**TABLE 1: AGENCY SUBMISSIONS & ToxFree Response**

| No | Key Points & Recommendations   | ToxFree Response   |
|----|--|--|
| 1  | <p><b>NSW Environment Protection Authority</b></p> <p>NSW EPA reviewed the EA Submission and (our understanding of their) comments of 13 June 2017 is provided below:</p> <ul style="list-style-type: none"> <li>• Briefly summarises the proposed activities and BluBox air treatment system</li> <li>• Agrees with EA conclusion that operation of the BluBox treatment system would not adversely impact on air or water quality;</li> <li>• Considers the proposed modification is a low risk with respect to noise impacts</li> <li>• Recommends that the four roller doors, particularly the eastern door facing residences, be kept closed or fitted with fast opening/closing shutters to be operated from 5.00am to 7.00am and 10pm to 11pm where practicable, subject to safety and operational considerations.</li> </ul> <p>ToxFree is amenable to being Conditioned on the basis of this recommendation ie</p> <p><i>“the four roller doors, particularly the eastern door facing residences, to be operated from 5.00am to 7.00am and 10pm to 10pm, be kept closed where practicable, subject

Sheet Subject
**TURNING PLAN SHEET 5 -
LOADED VEHICLE TO
WEIGHBRIDGE**

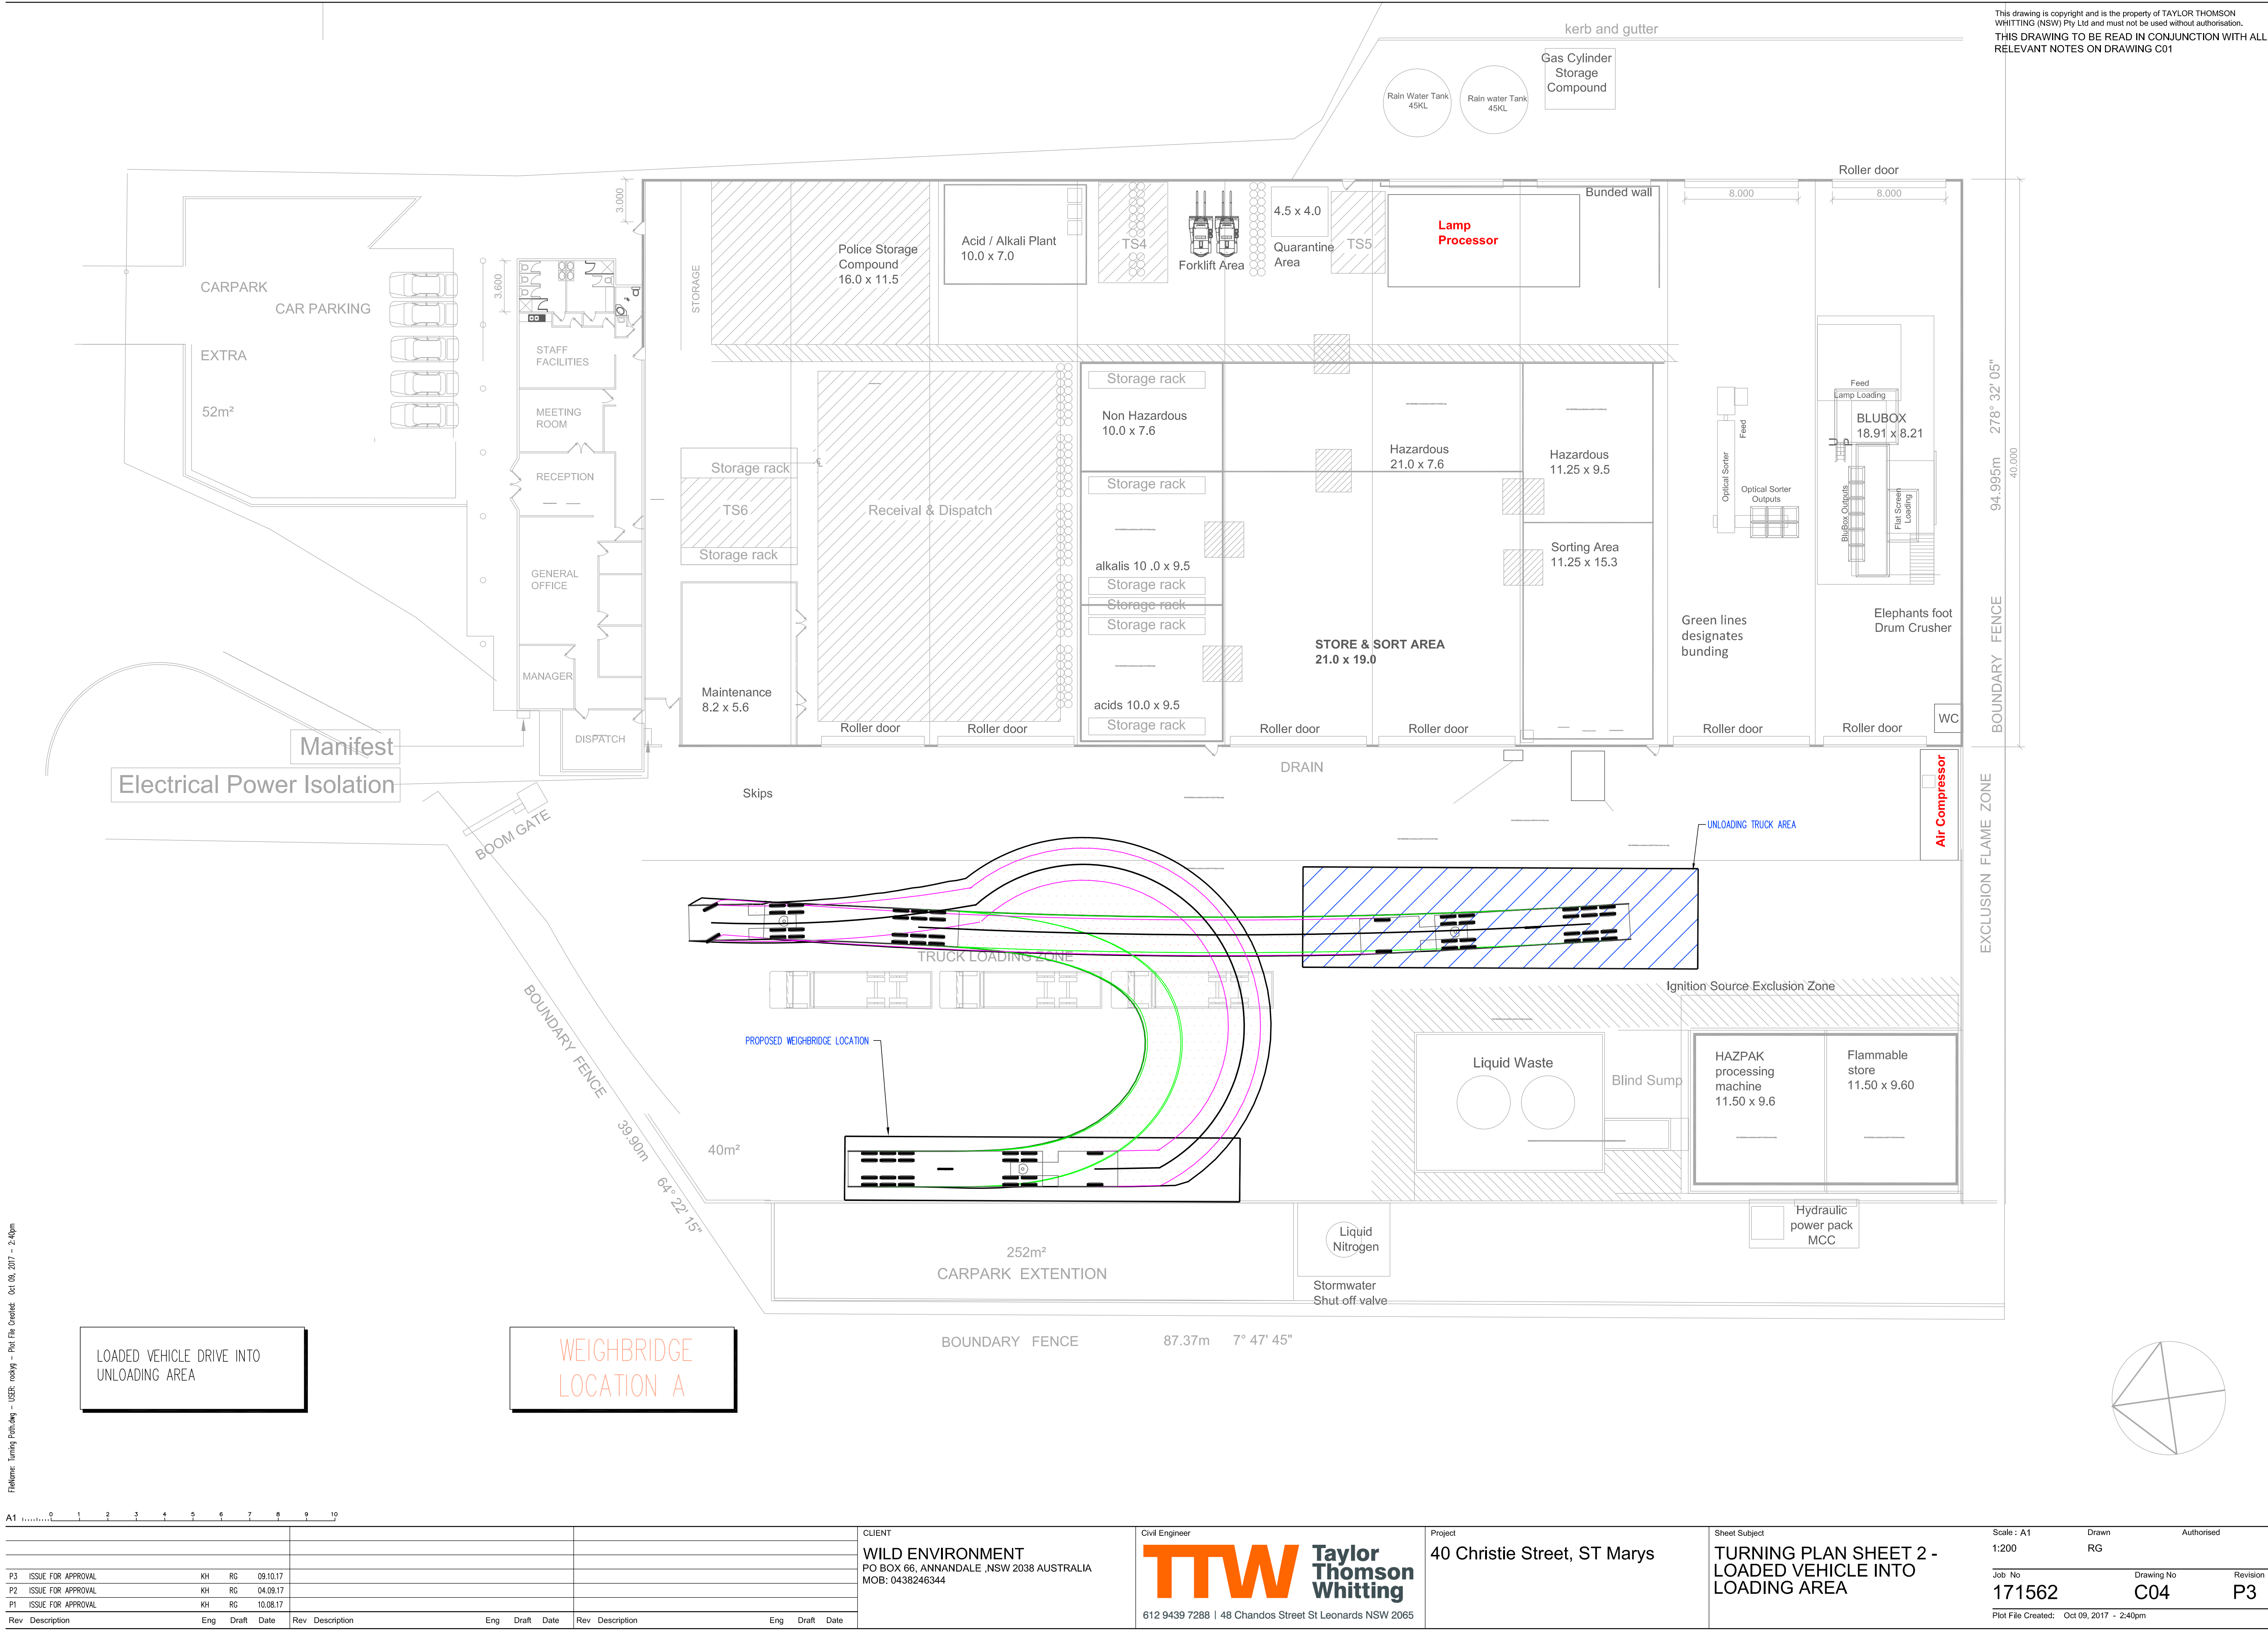
| No | Key Points & Recommendations   | ToxFree Response  |
|----|--|---|
|    | <p><b>Truck Movements</b></p> <p>Swept paths for truck movements required demonstrating;</p> <ul style="list-style-type: none"> <li>• Location of the weighbridge is suitable and will not have negative impact on safe manoeuvrability of trucks and cars within the site</li> <li>• Trucks delivering/picking up materials from the roller doors</li> </ul>  | <p>Please refer to the attached TTW report and accompanying Plans C02, C03, C04, C05. The analysis demonstrates and concludes that the location is suitable, will not have a negative impact on safe manoeuvrability of trucks or cars.</p> <p>Line marking will be carried out, and spotters will be used for turning of heavy vehicles (largest semi-trailers). No storage would be allowed within the marked turning areas. Loading and unloading will be carried out when the trucks are parked between the weighbridge and existing building. All drivers will be inducted and tool-boxed in to safe site traffic movements and procedures.</p> <p>Swept path analysis (Plans C02 &amp; C03) are conservative, and will be verified upon installation. Appropriate impact protection and signage will be installed as required.</p> <p>The Assessment concludes that the site and operations are suitable for the proposed traffic, access and parking arrangements.</p> |

| No | Key Points & Recommendations  | ToxFree Response   |
|----|---|--|
|    | <p>Provide swept path diagrams to demonstrate compliance with AS2890.1: Parking facilities Part 1: Off-street car parking.</p>  | <p>The TTW Report and Plans CO3 &amp; C04 set out swept path analysis and conclude compliance with AS2890.1 Part 1.</p>  |

Scale	A1	Drawn	RG	Authorised	
Job No	171562	C02			
Plot File Created	Oct 27, 2017	10:47am

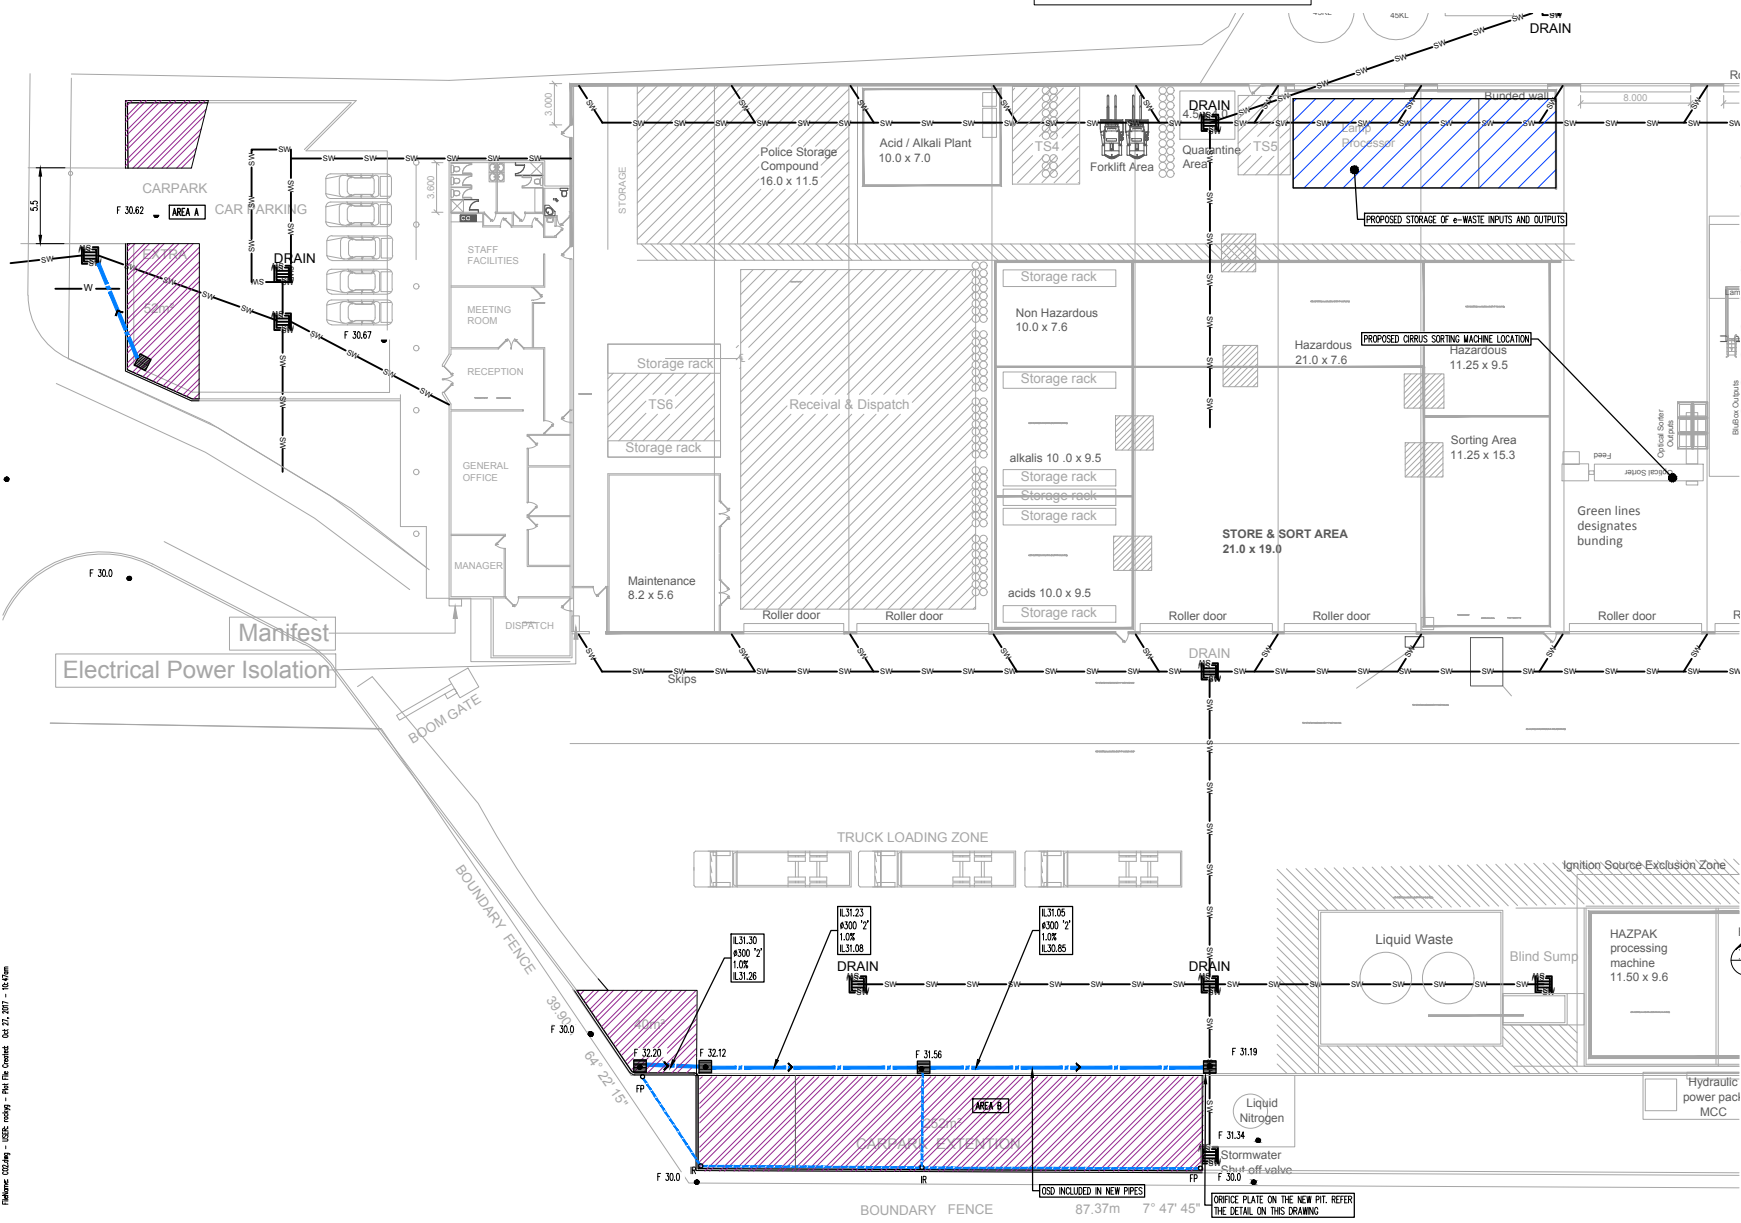
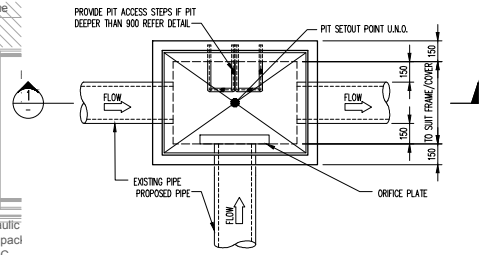
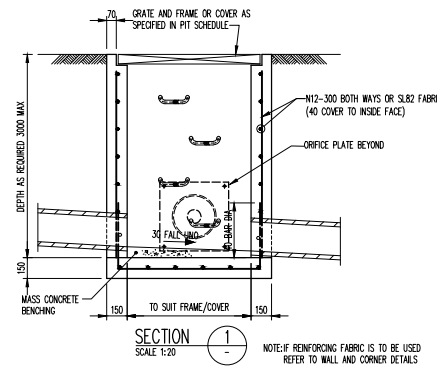
| No | Key Points & Recommendations  | ToxFree Response  |
|----|---|---|
|    | <p><b>Drainage:</b></p> <p>Site Plan indicates an increase in the hardstand/impervious area of the site. Stormwater drainage plan required, including pre-development and post-development calculations</p> | Please refer to the attached TTW report   |

| No | Key Points & Recommendations  | ToxFree Response   |
|----|---|--|
|    | <p><b>Stormwater Drainage Plan</b></p> <p>Provide stormwater drainage plan to:</p> <ul style="list-style-type: none"> <li>• demonstrate the proposed impervious areas with finished surface levels along the western property boundary</li> <li>• stormwater connection pipes to be provided should water not be able to discharge to existing system</li> <li>• Drainage Plan should address WSUD and OSD requirements for increased impervious areas, to Council's Policy requirements</li> </ul> | <p>The TTW Report provides stormwater drainage and retention analysis for increased impermeable areas, drainage plan concept in accordance with Council's WSUD and OSD Policy requirements.</p>  |
